Reference 3/2020/0667

Conversion and change of use of former fish hatchery building to 3 holiday let units, and creation of associated car park for 6 vehicles at the Witcher Well Fish Hatchery, Whitendale Road, Dunsop Bridge, BB7 3BL.

I write further to my letter of 27 November 2020, objecting to the above planning Application and in response to the letter of clarification and amended documents submitted by the Applicant, 28 January 2021.

Site Plan as Proposed 1:200

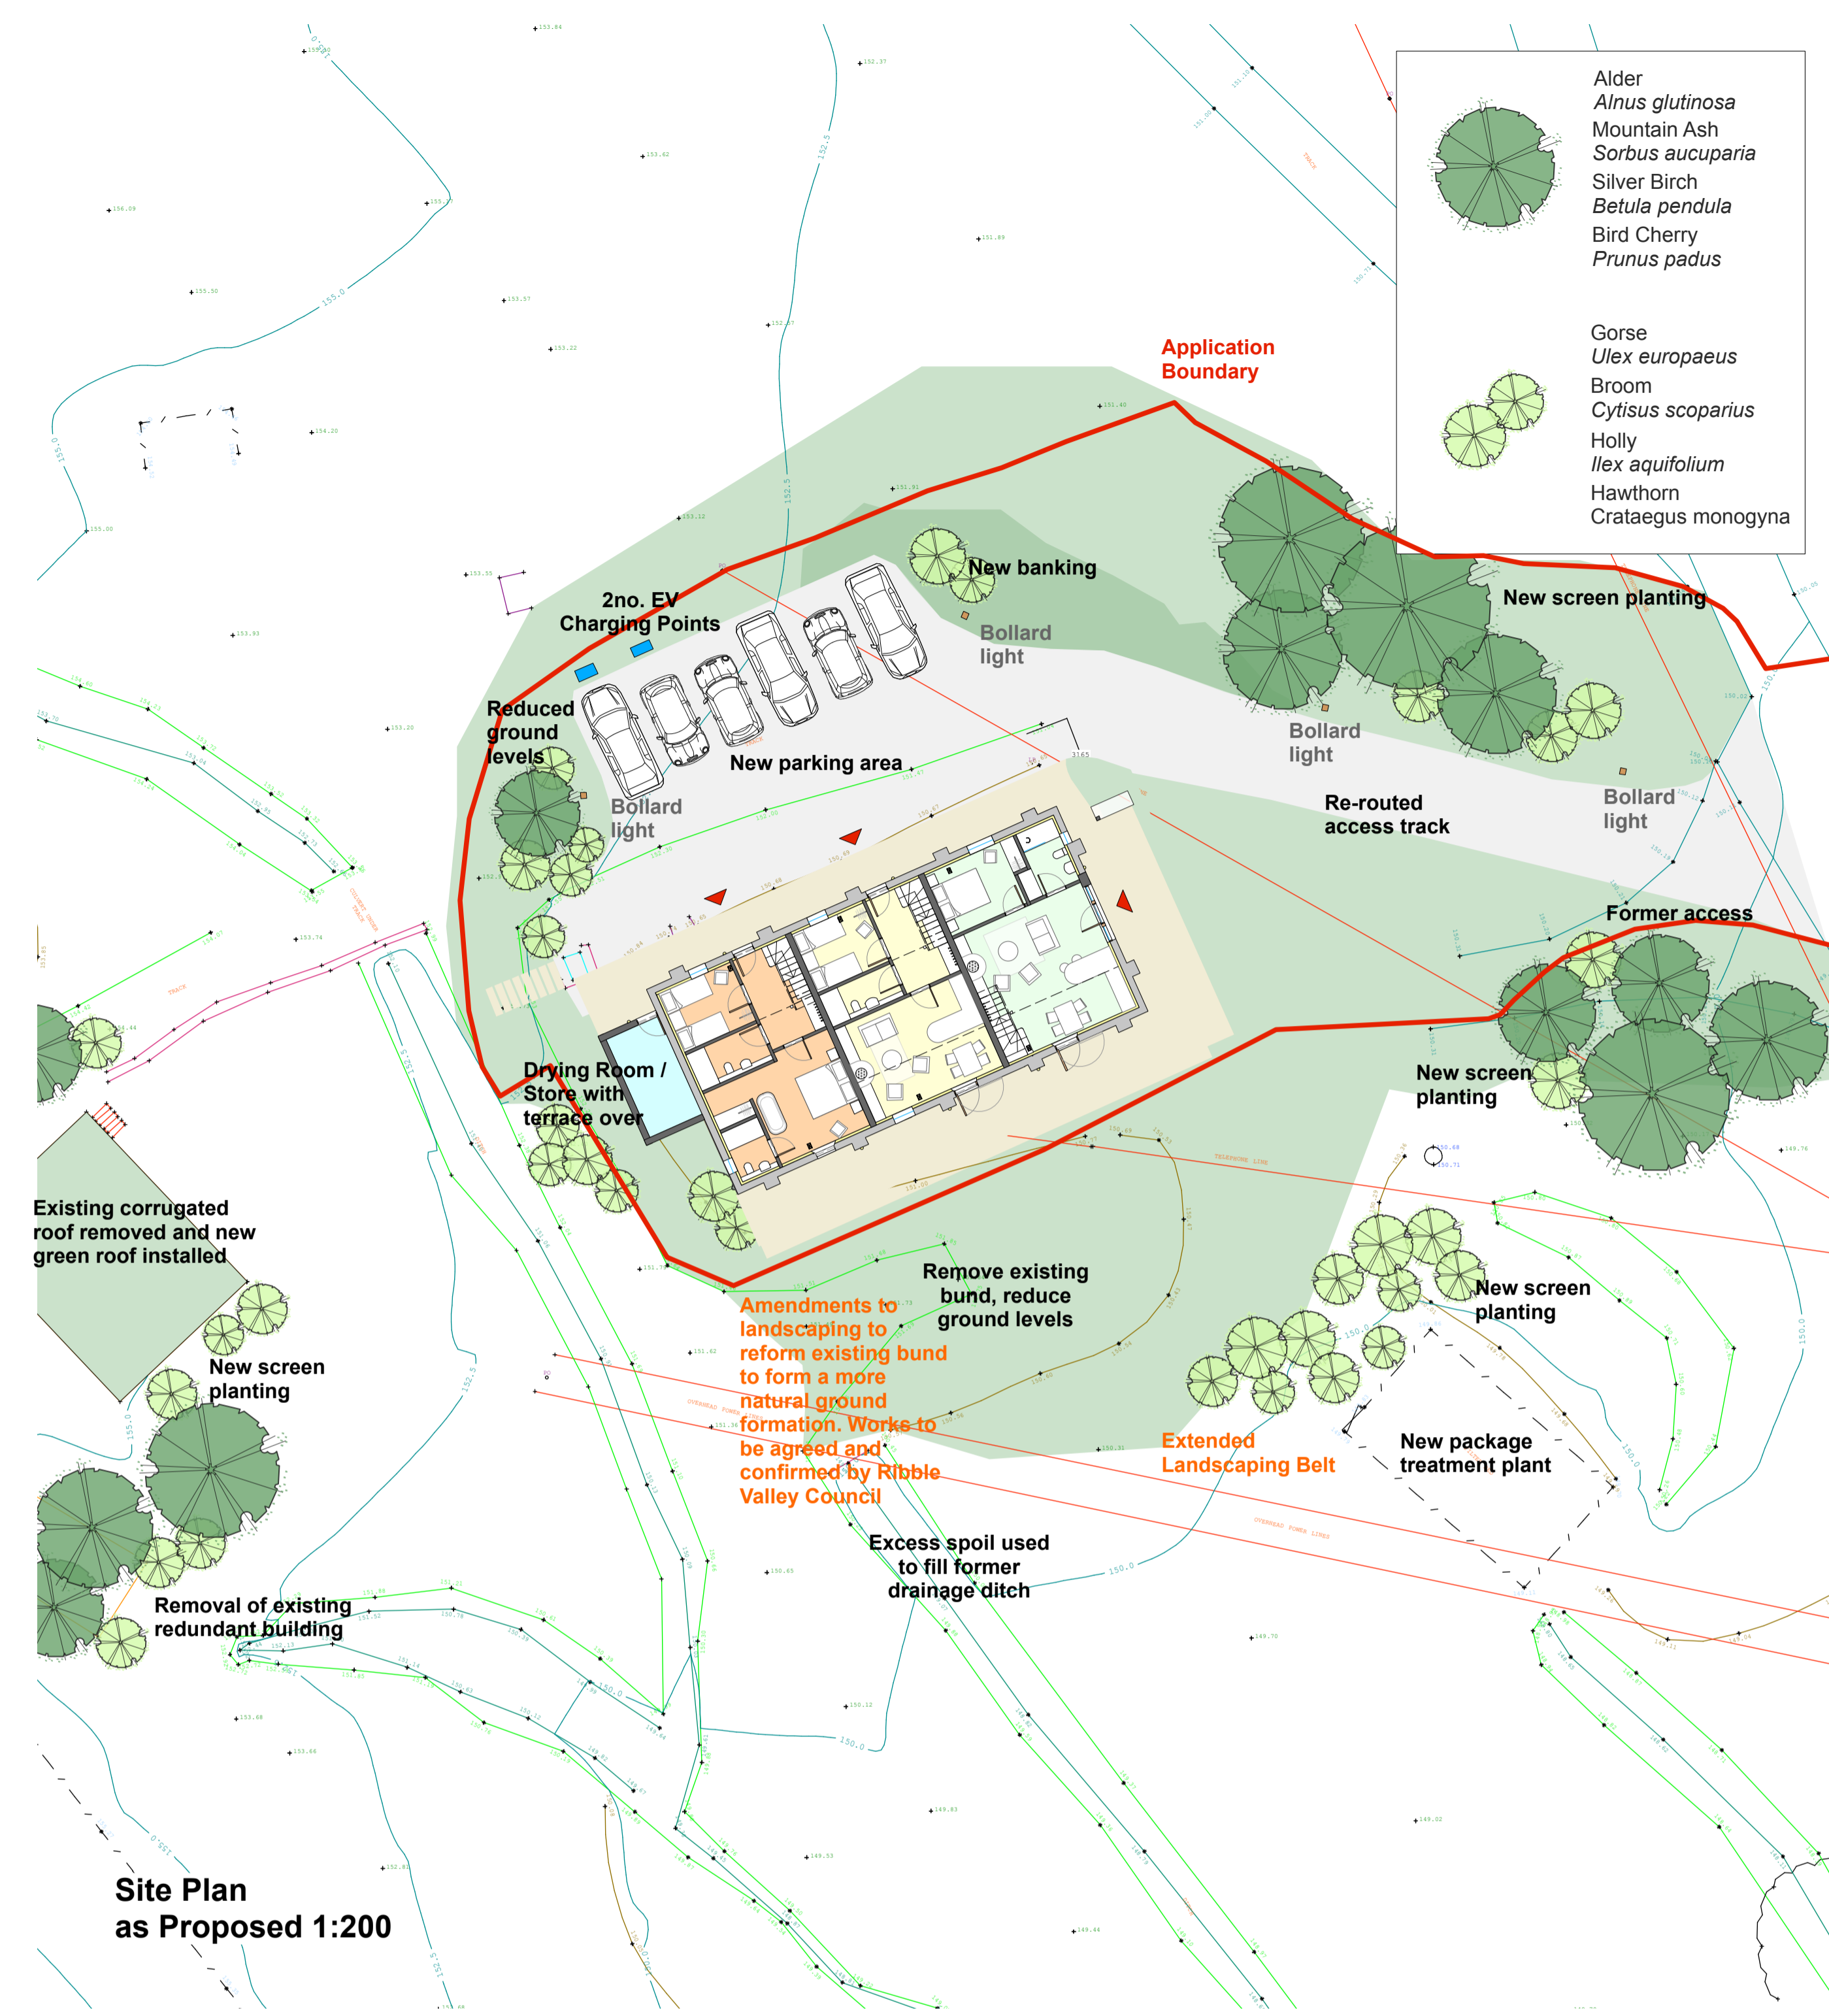
We note the plans for screening include planting oak, mountain ash and silver birch. This does not include the wide range of planting recommended in the ecology report. Representations as to the proprietors commitment to providing screening have already been highlighted, and it remains a concern that a monkey puzzle tree has already been planted, (despite the suggesting that the site is being used for storage only of the monkey puzzle trees). Furthermore, as stated previously, many of the trees already planted are dead or pot bound. In any event, the proposal to plant slow growing trees will mean screening of the development is likely to be visible for many generation to come. The planting is also only likely to provide screening during the summer months when there is foliage.

It is assumed outdoor lighting will be in operation at the sight continually to ensure the safety of guests. The ecology report fails to address how the constant lighting will impact on the surrounding wildlife, or the constant human presence (and the associated noise, waste management etc.) should this business venture be successful if generating year round letting.

Ground Floor Plan as Proposed
1:50 Scale

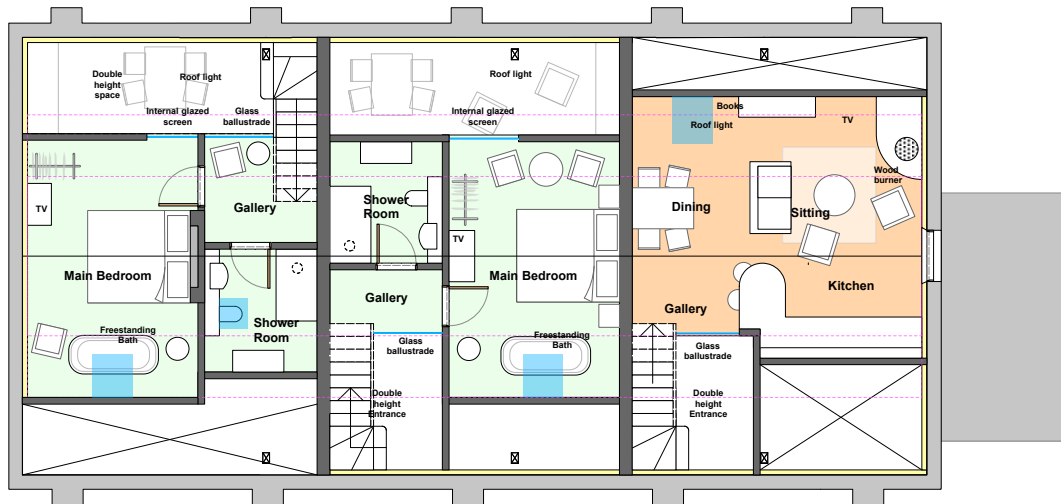
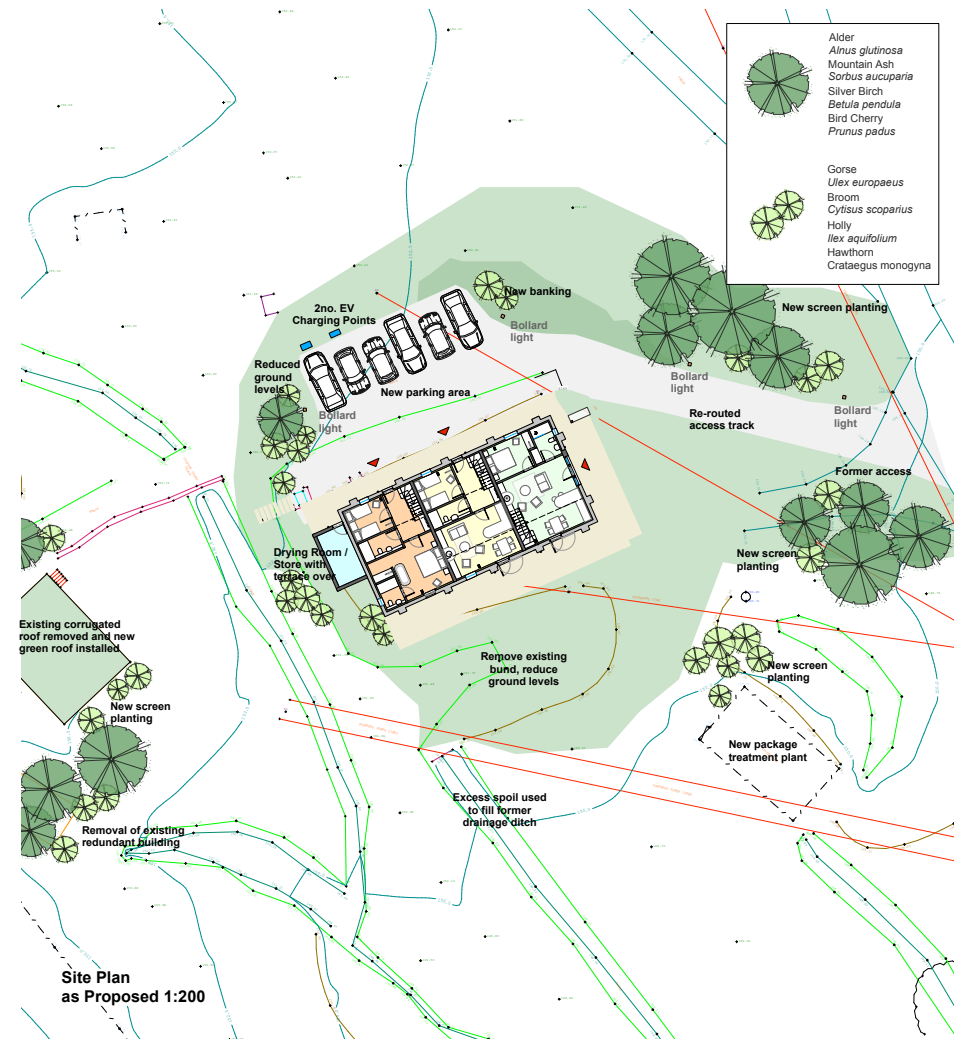
Whilst a number of sky lights have been removed from the original plans, a number remain. This cannot be said to be sensitive lighting and will create unacceptable overspill impacting on both the wildlife and the dark skies in the AONB. Whilst there is currently a flood light at the site, it has never been used [REDACTED] and would have been seldom used previously as the site was not used in the evenings.
